MASTER LIST OF ISSUE-SPECIFIC QUESTIONS

Grid Alignment & Technical Justification (Great Moulton)

CONCEPT SURFACE WATER DRAINAGE
BESS AND 400KV PROJECT SUBSTATION
BESS SITE

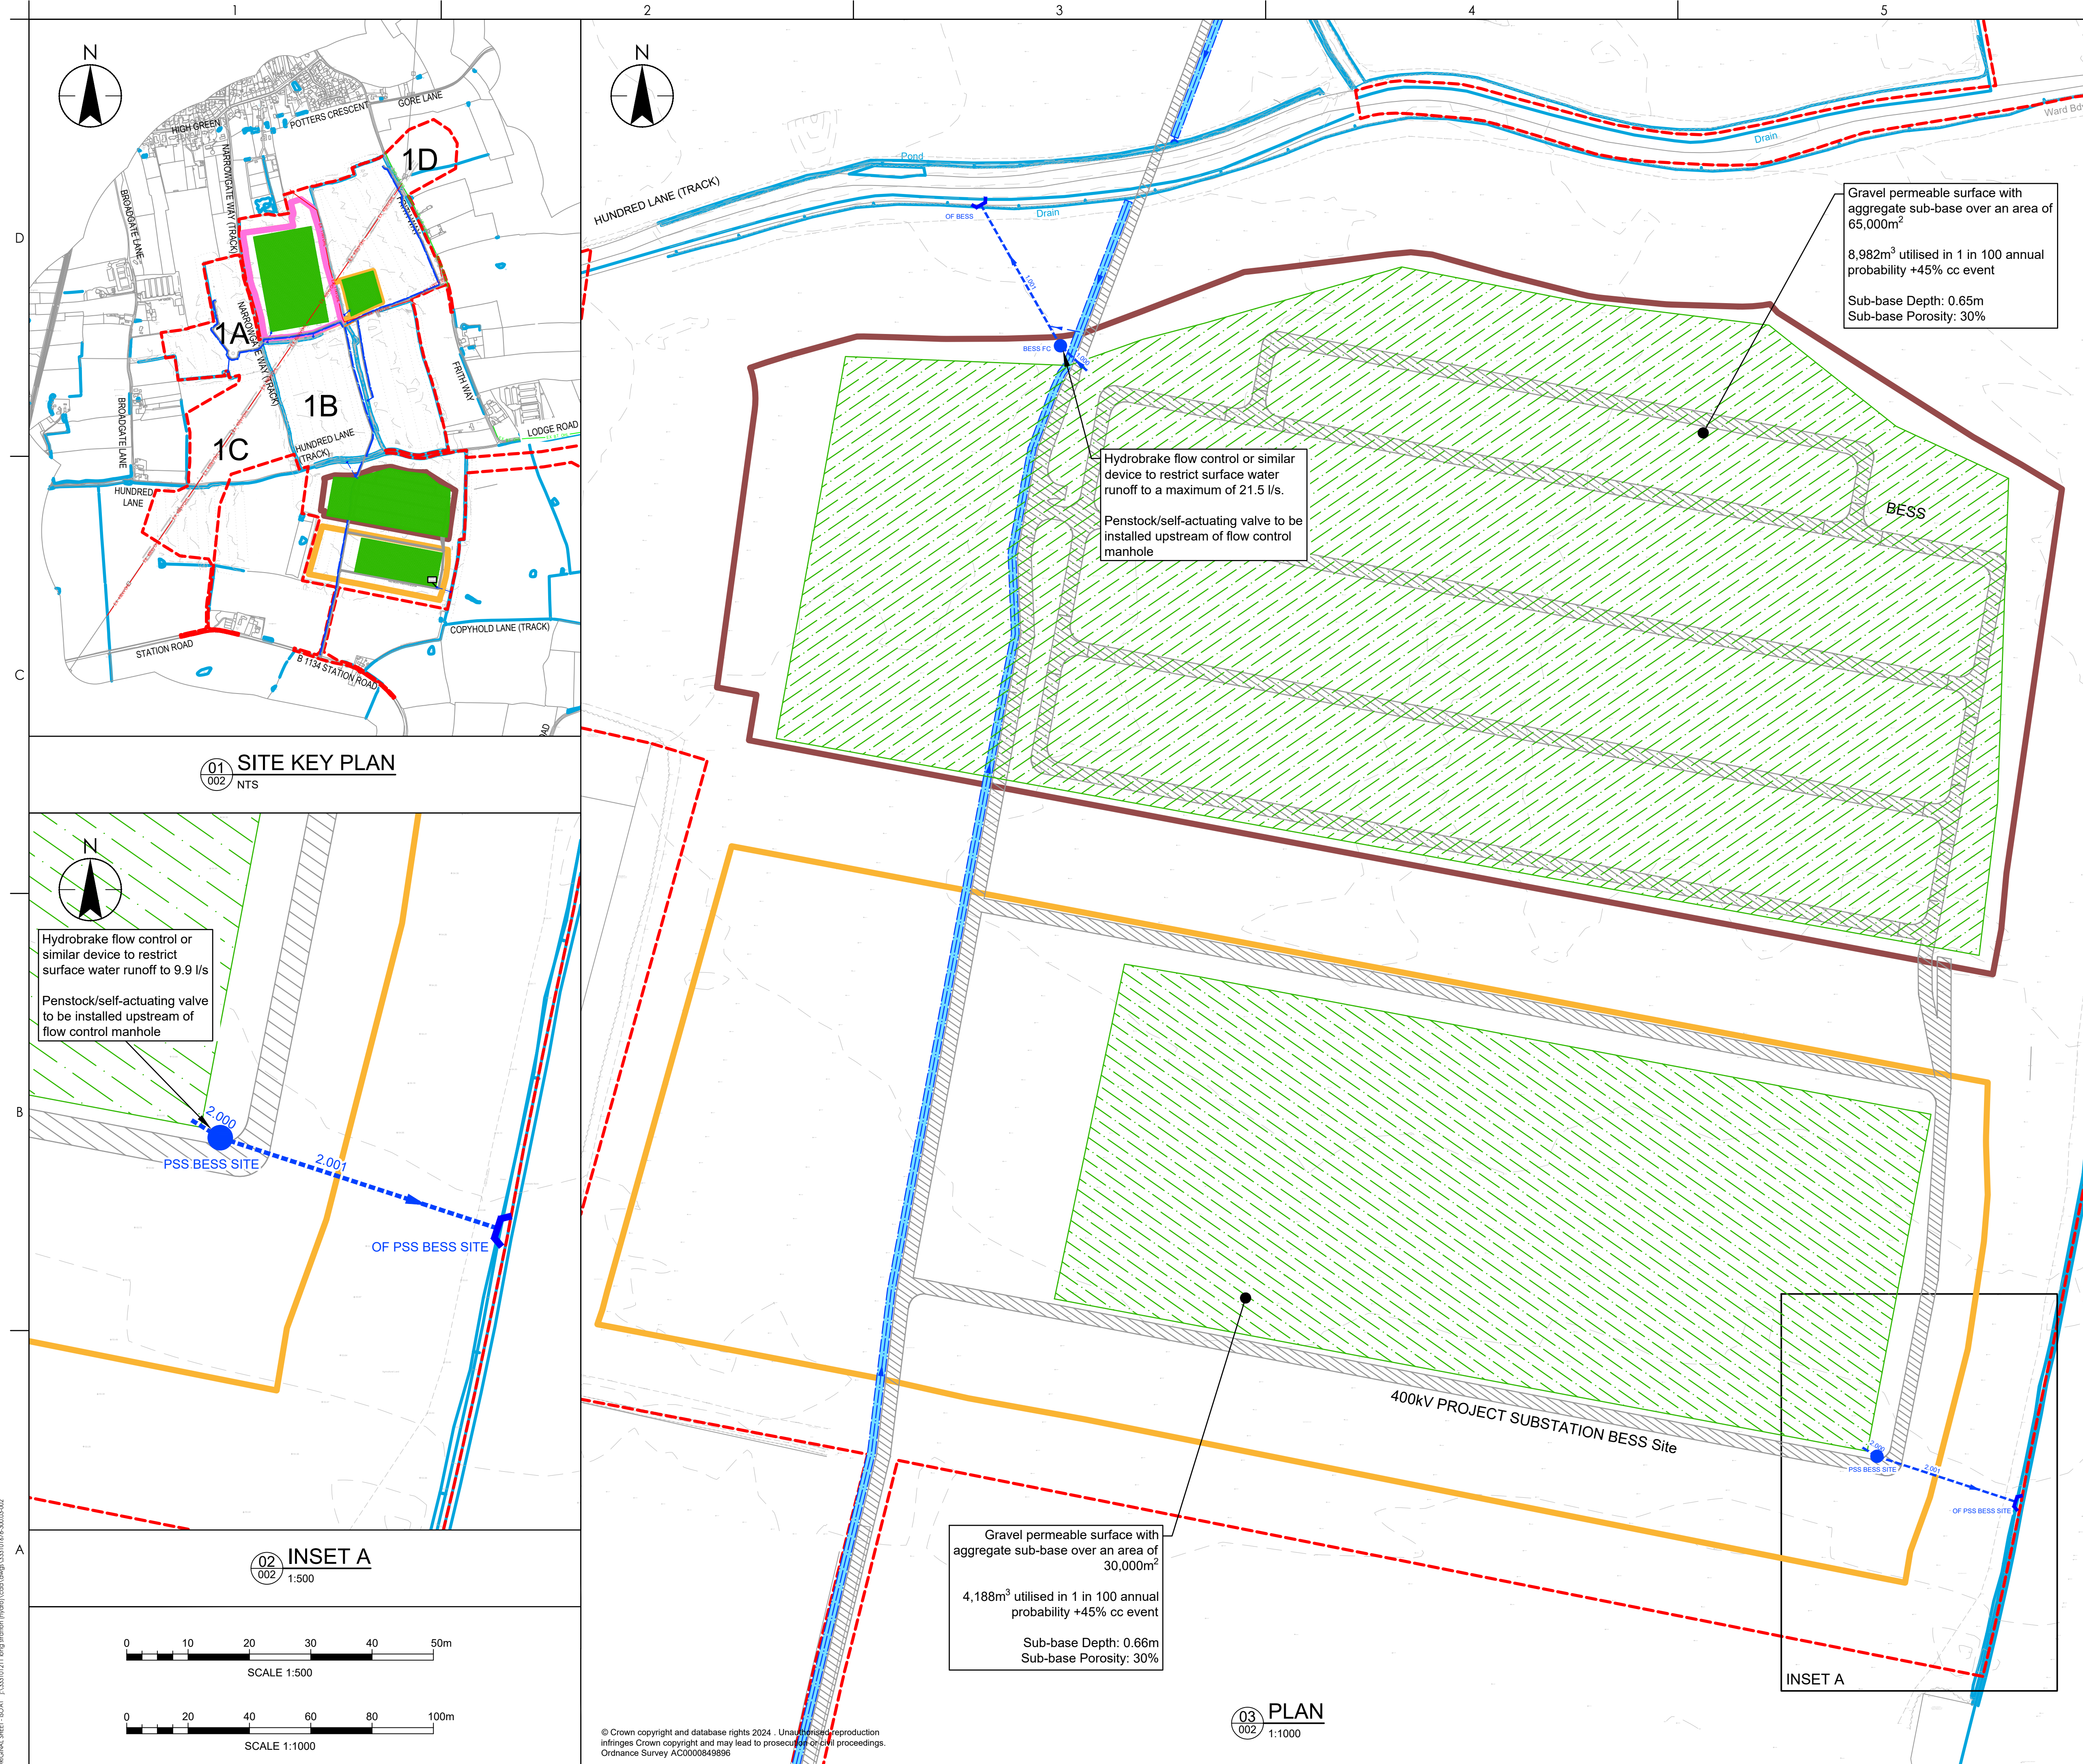
6. The Great Moulton hub—hosting the massive Battery Energy Storage System (BESS) and up to three 400kV substations—sits at the headwaters that drain into the River Tas catchment. If a significant chemical fire occurs at the BESS facility, what specific surface water attenuation systems are designed for Great Moulton to ensure that toxic, firefighting chemical run-off is 100% contained on-site and cannot leak into the local ditches feeding the River Tas or Starston Beck?

9. The proposed Great Moulton BESS facility and 400kV substation cluster sit at the headwaters of Starston Beck, a high-value ordinary watercourse that feeds the River Waveney. Given that Starston Beck has a documented history of severe flash flooding that impacts downstream residential properties, what specific surface water attenuation calculations has the Applicant used to guarantee that a 1-in-100-year storm event will not overwhelm the Great Moulton site, wash toxic battery contaminants into Starston Beck, and cause catastrophic ecological and property damage down-river?
